WRITTEN SUBMISSION AND SUMMARY BY GILLIAN ANLEZARK (Ref 20019632) ON BEHALF OF COGS (CYCLING OPPORTUNITIES GROUP FOR SALISBURY) TO APPLICATION BY HIGHWAYS ENGLAND FOR AN ORDER GRANTING DEVELOPMENT CONSENT FOR A303 AMESBURY TO BERWICK DOWN

1st May 2019

Drawing Title: **GENERAL ARRANGEMENT DRAWINGS REGULATION 5(2)(o) SHEET 8 OF 15**

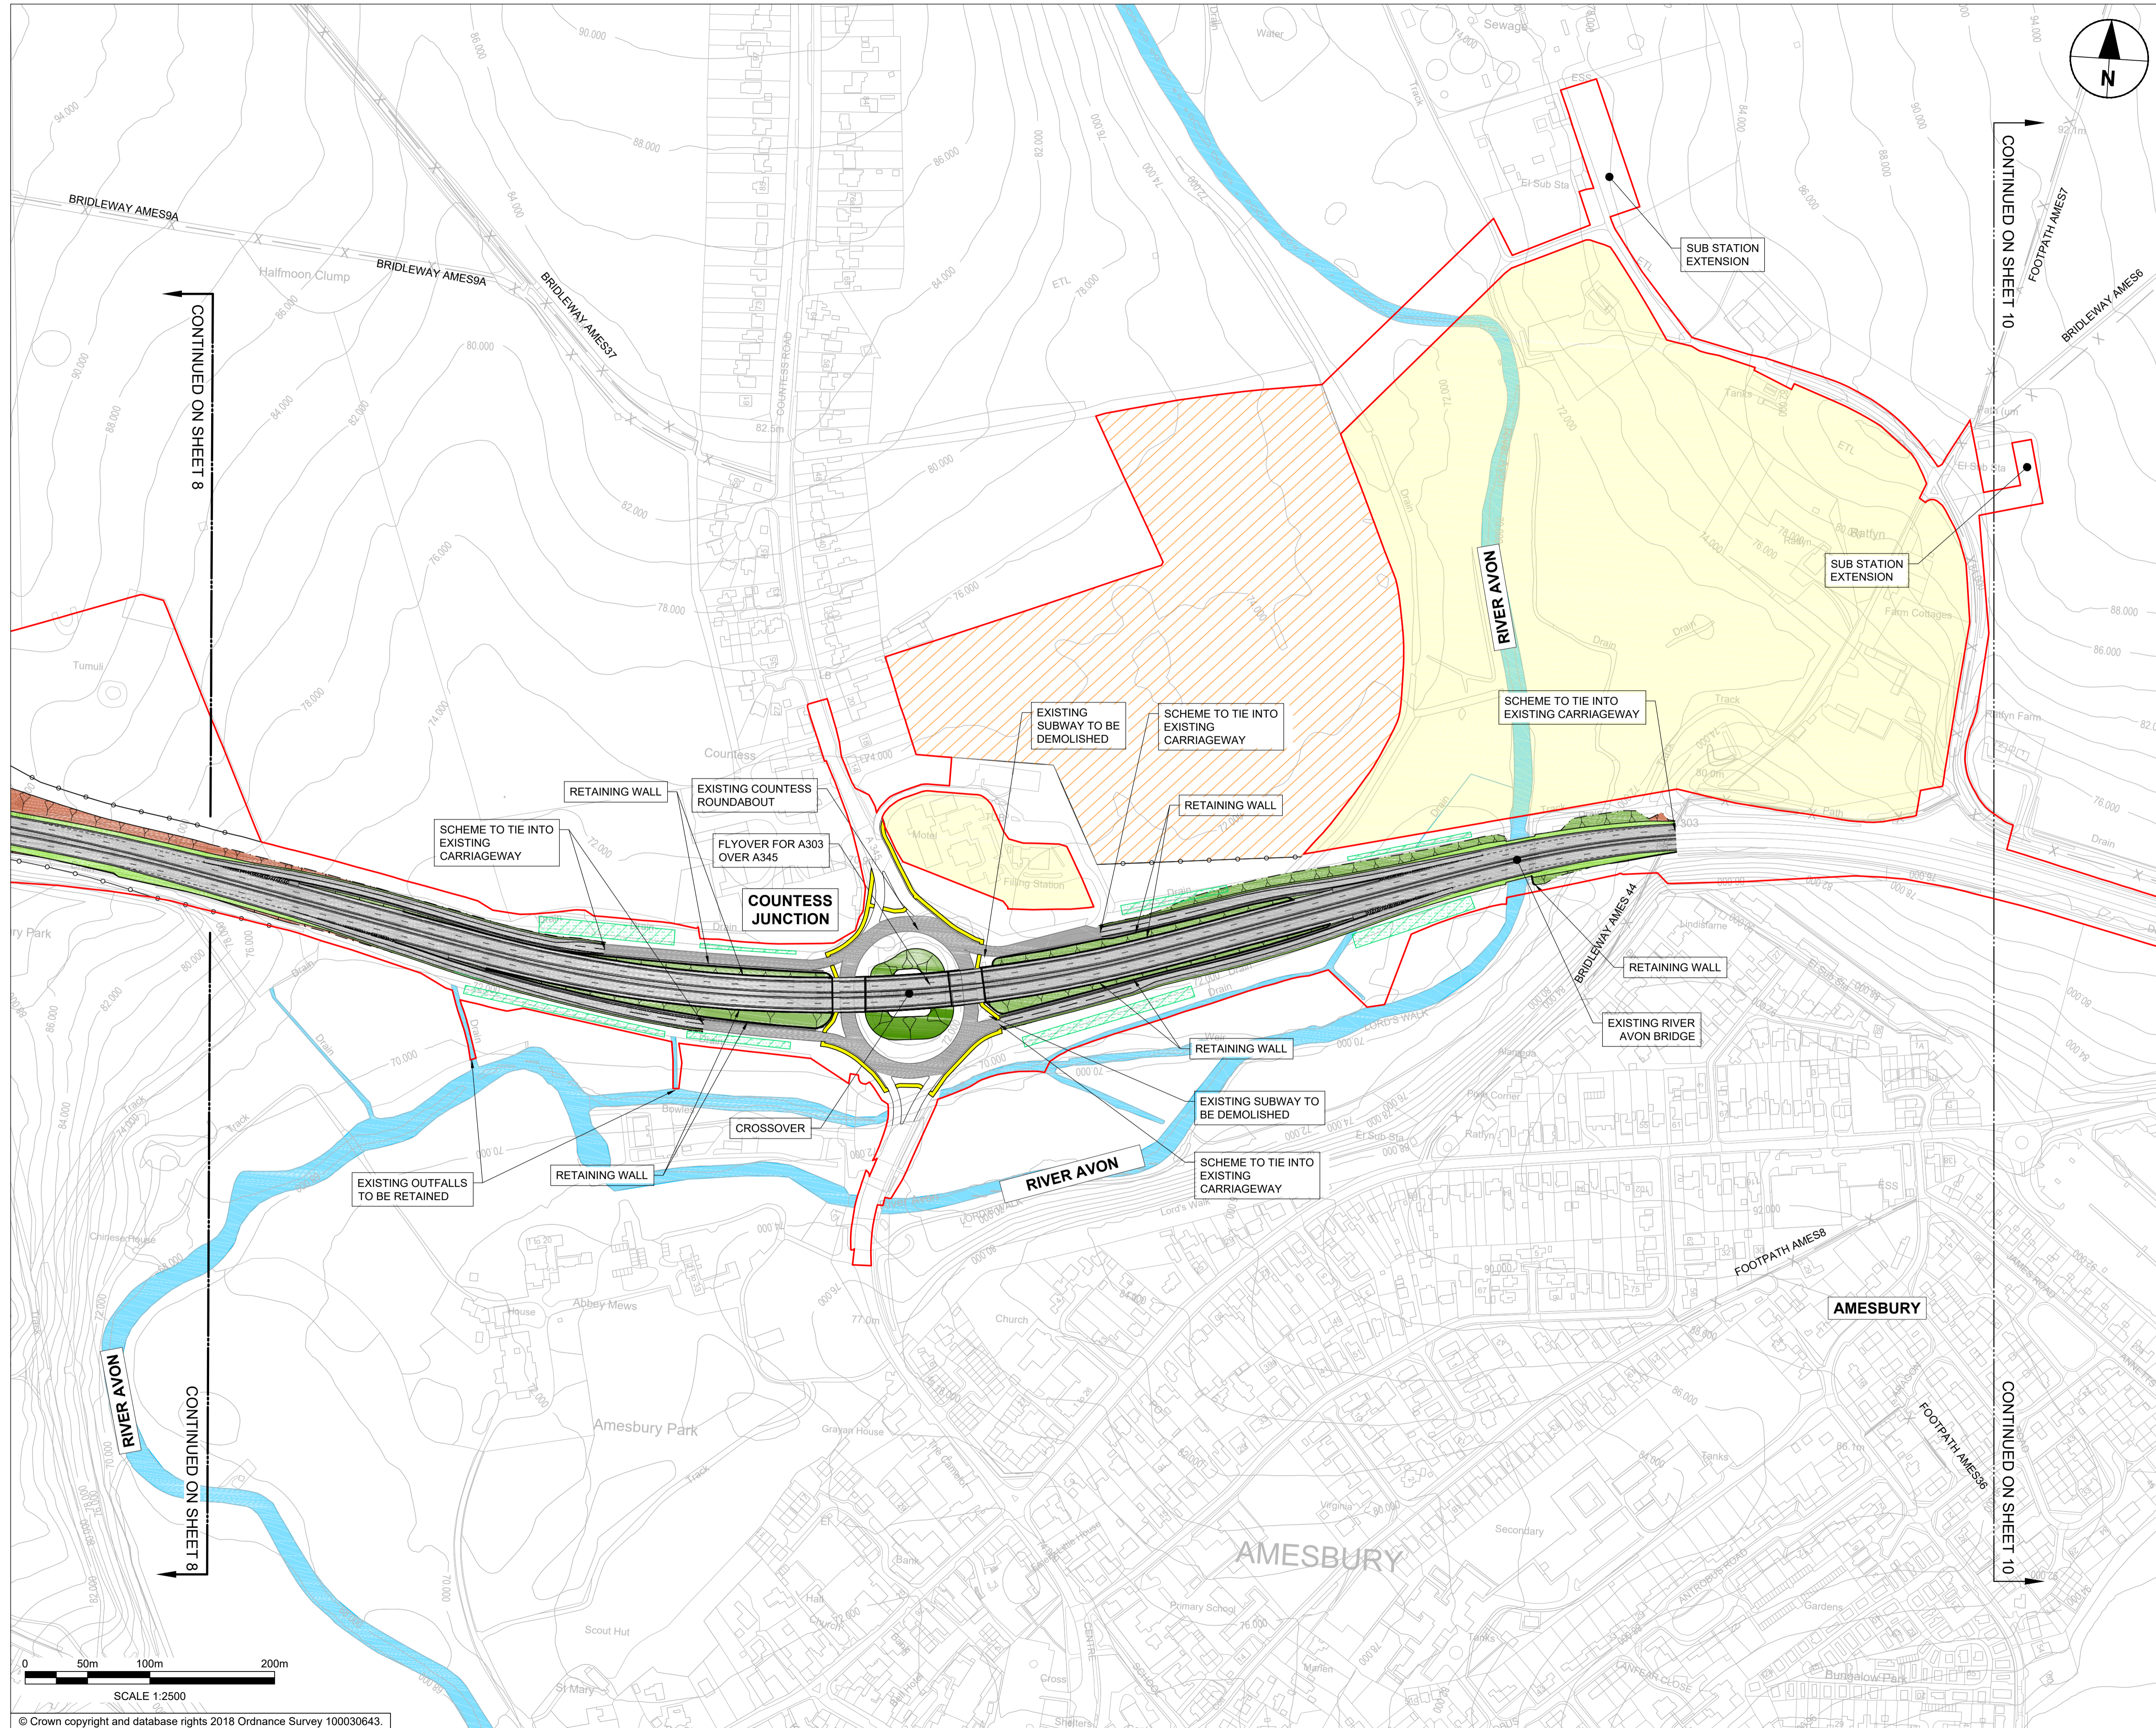
We await details of a proposed cycling route at Countess roundabout, the route on sheet 9 of TR010025 - 2.9 is shown as a footway only, although section 6.5.6 of 7.2 Design and Access Statement refers to use by cyclists to access NCN45 (access route not specified, but presumably via Amesbury or Durrington, a contribution towards providing this route would be a welcome legacy project as mentioned above).
